## DELEGATED HOUSEHOLDER DECISION

18 HAZELWOOD DRIVE PINNER

Officer Comments: The application benefits from the above planning permission for the conversion of roof to gable end and a rear dormer. The overall height of the gable and the ridge height has increased and is the subject of this application.

9 Front Elevation (Proposed)
2302-A-200 1 : 100

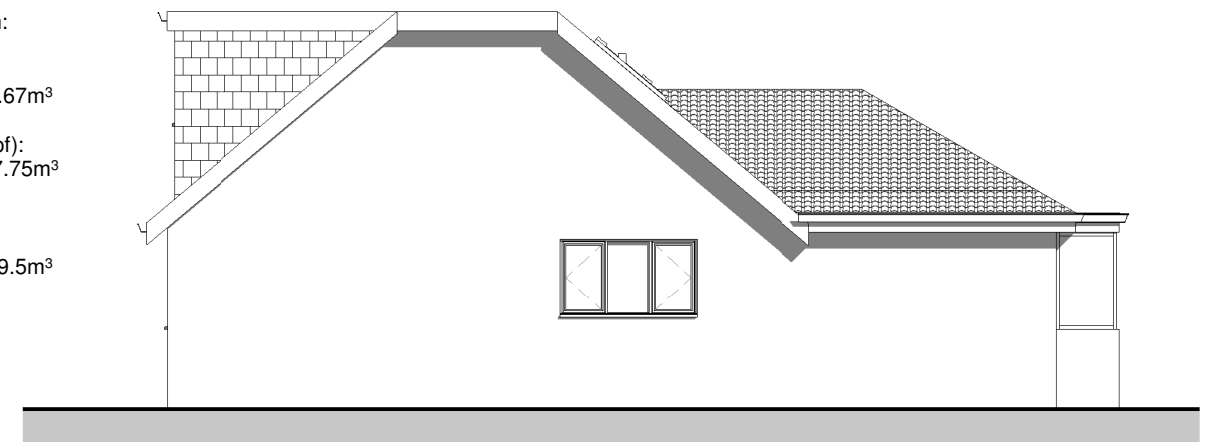
The application proposes 3 no. roof lights on the front elevation and an additional window on the side gable elevation. There are no objections to this aspect of the proposal.

10 Side Elevation 01 (Proposed)
2302-A-200 1 : 100

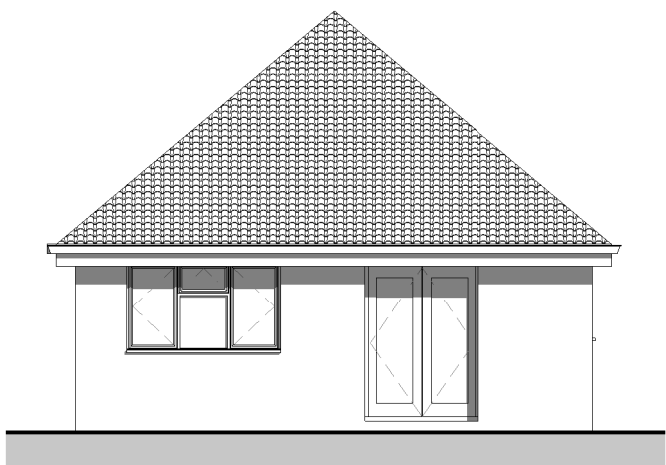
In terms of the hip to gable and rear dormer, it is not considered that it would significantly impact upon neighbouring properties in terms of overshadowing, overlooking or loss of light. It is noted that there are concerns that the gable window would result in overlooking and a loss of privacy. In the event of an approval, a condition will be secured on the window to ensure it is obscurely glazed and non-opening above 1800mm. It is not considered that the proposal would result in an unacceptable degree of overlooking or loss of privacy.

The gable end first floor side elevation window serving the bathroom shall be glazed with permanently obscured glass to at least scale 4 on the Pilkington scale and be non-opening below a height of 1.8 metres taken from internal finished floor level for so long as the development remains in existence.

11 Rear Elevation (Proposed)
2302-A-200 1 : 100

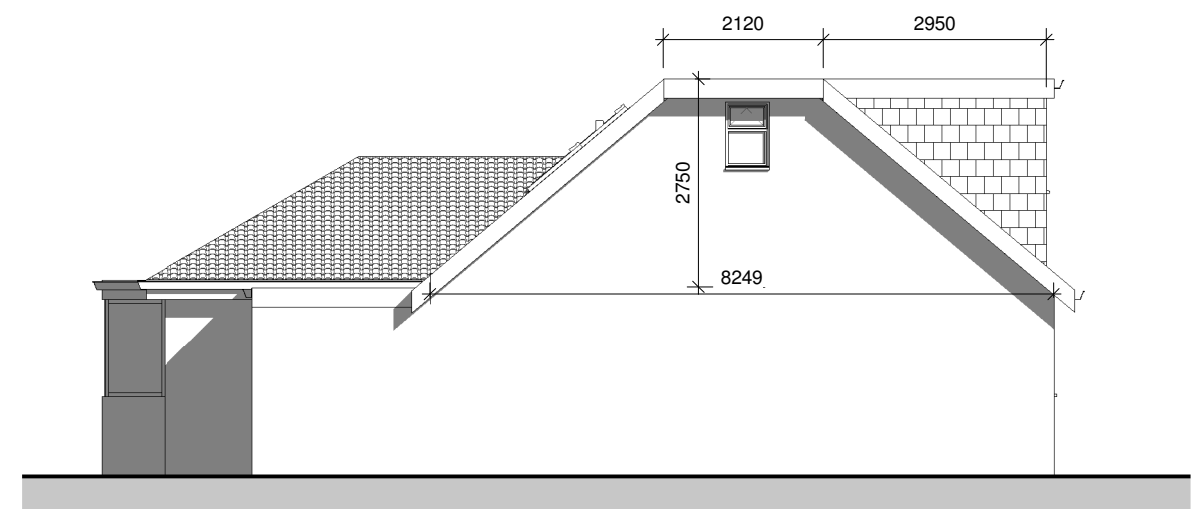
The application proposes part retrospective planning permission for the erection of a rear dormer extension with hip to gable extensions and 3 x front facing roof lights, a side window and changes to existing roof form. The site benefits from planning permission for the conversion of roof space to habitable use to include a rear dormer and conversion of roof from hip to gable end (Application Reference: 77117/APP/2022/2597). However, the overall scale of the hip to gable conversion has increased in terms of the height and width; and the rear dormer has increased in height and width. The overall ridge height has increased by approximately 0.3m.

Whilst the overall scale of proposed roof works has increased, the general design principles remain and it is not considered that the proposed development would appear out of character within the street scene. The proposal has increased the overall height by 0.3m, however in viewing the bungalow in this context with the surrounding properties, it does not appear out of character to a degree that has a harmful impact on the surrounding street scene. It is noted that No. 14 and No. 24 Hazelwood Drive benefit from double hip to gable conversions and rear dormers. No. 24 Hazelwood Drive benefits from a similar large rear dormer which spans the width of the rear roof slope. In this regard, it is considered that rear dormers are visible in the area, and there are large rear dormers present.
